From: Planning
Sent: 25 September 2020 10:21
To: Harriet McCartney
Subject: FW: Planning application No: 3/2020/0669

Re 3 Bradley Court BB7 3LY

comments: I wish to make the following comments in relation to 3/2020/0669: Whilst I appreciate the applicant has taken in to consideration the Planning Authority comments in the refusal of their previous application 3/2020/0344. I have concerns regarding the scale, appearance and design of the new planning application 3/2020/0669, my reasons being that if approved it will be a significant change to a historic building in the Forest of Bowland AONB and a loss of historic features that will have a visible and noticeable impact on the character of the area. I also feel that if approved this will encourage further applications which would fundamentally impact on the look and feel of Bradley Court. The sympathetic conversion of Bradley Hall Barns in to 9 dwellings in 1991 (3/1991/0755) to form what is now Bradley Court ensured that the barns were kept to their original format but sensitively converted, therefore they now enhance the area of outstanding natural beauty in which they stand, in harmony with the local landscape. The planning appli

4 Proposed Side (south) Elevation
1 : 100

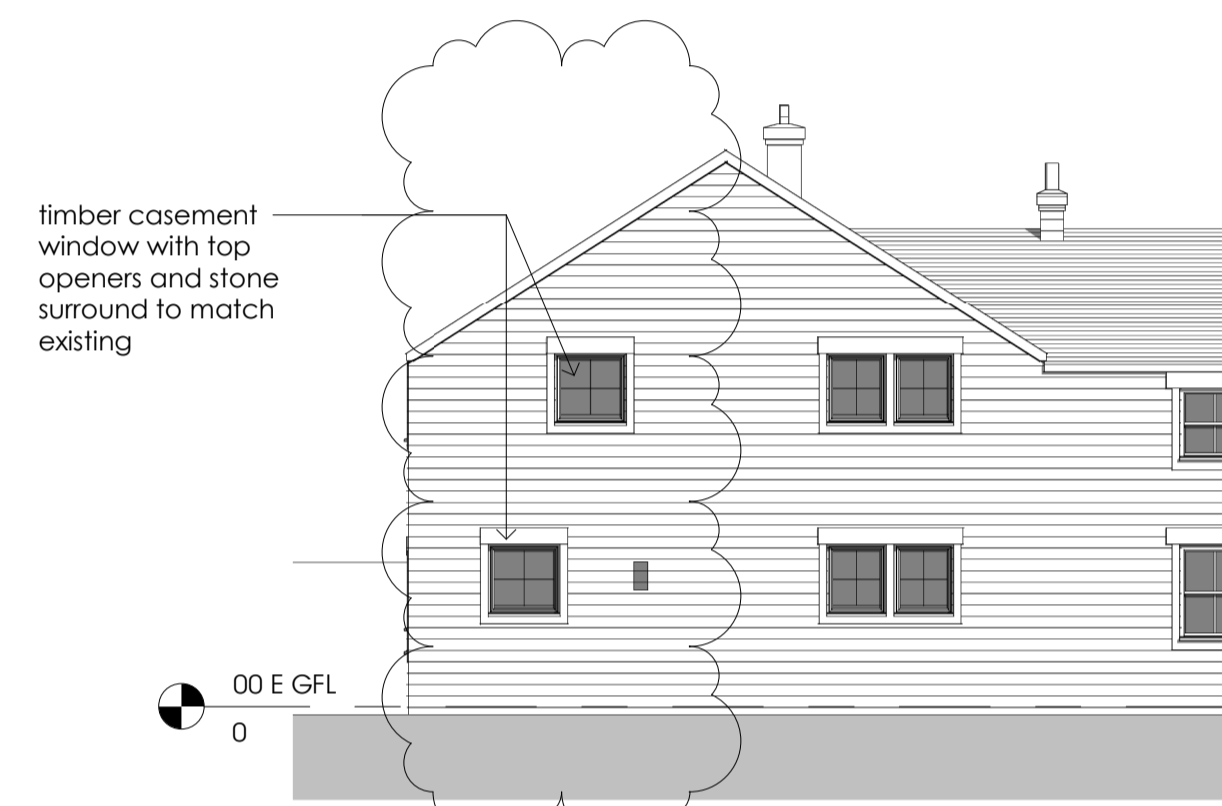
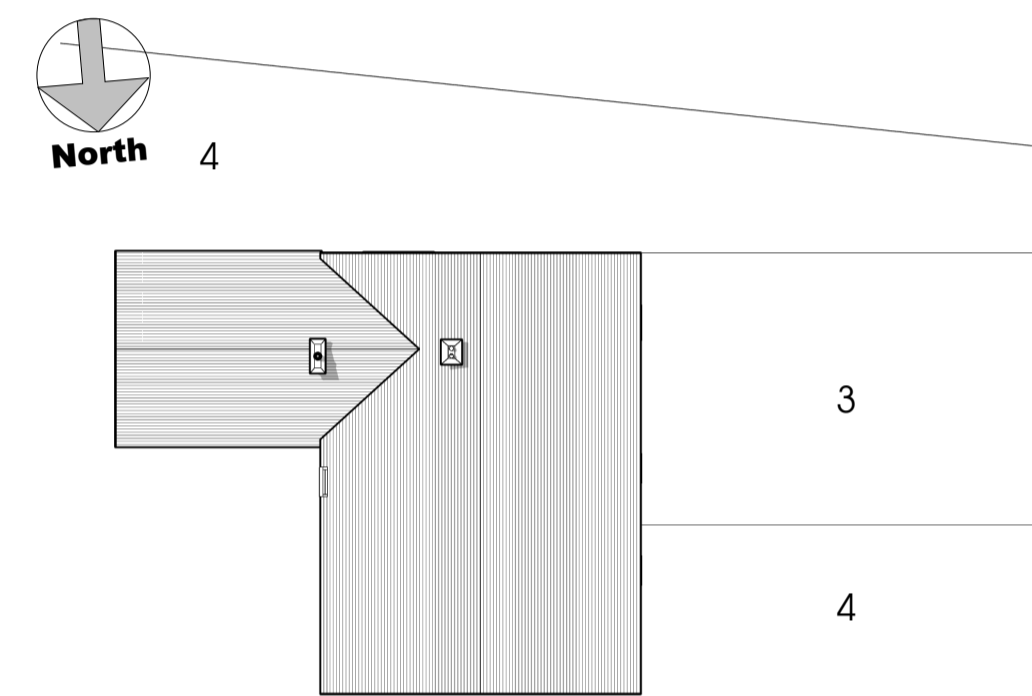
1. That any window downstairs should not be sighted so as to interfere with the original corner stones that are inset , and shows how the Original Barn was constructed and takes into account the choice small window light and reflect the style and design sympathetically.

The plan submitted with the application does not show the alignment of the stonework to the proposed fenestration and i ask the planning committee to consider if in their view the proposed downstairs window does emulate the Stile of the existing window light and if they consider it to be in keeping and sympathetic to it.

2. If the upstairs window is considered to be acceptable to the committee , may i suggest that none of the existing inset terracotta circular pipes are disturbed in any way. They have proved to be a highly successful nesting site and all year round shelter for House Sparrows which have been listed as an endangered species. May I ask that if the committee considers the application to be acceptable "that a condition be placed on the applicant " that no disturbance of these features takes place.

title: [REDACTED]
lastName: [REDACTED]
firstName: [REDACTED]
numberName: [REDACTED]
postAddress: [REDACTED]
postCode: [REDACTED]
refNo: 3/2020/0669
addDev: 3 Bradley Court Thornley Road CHAIGLEY Clitheroe BB7 3LY
comments: As long as the 2 additional windows, are in keeping with the rest of (Bradley Court Thornley Limited) Barn conversion, No problem. However, against any further development on this property

bathroom and lounge, the stipulation of the 1991 approval for the conversion of the barns was the preservation of original window and door openings and the retention of original beams which has resulted in dwellings with darker internal space, this is the character of the old barns. Please see photographs submitted with comments under 3/2020/0344
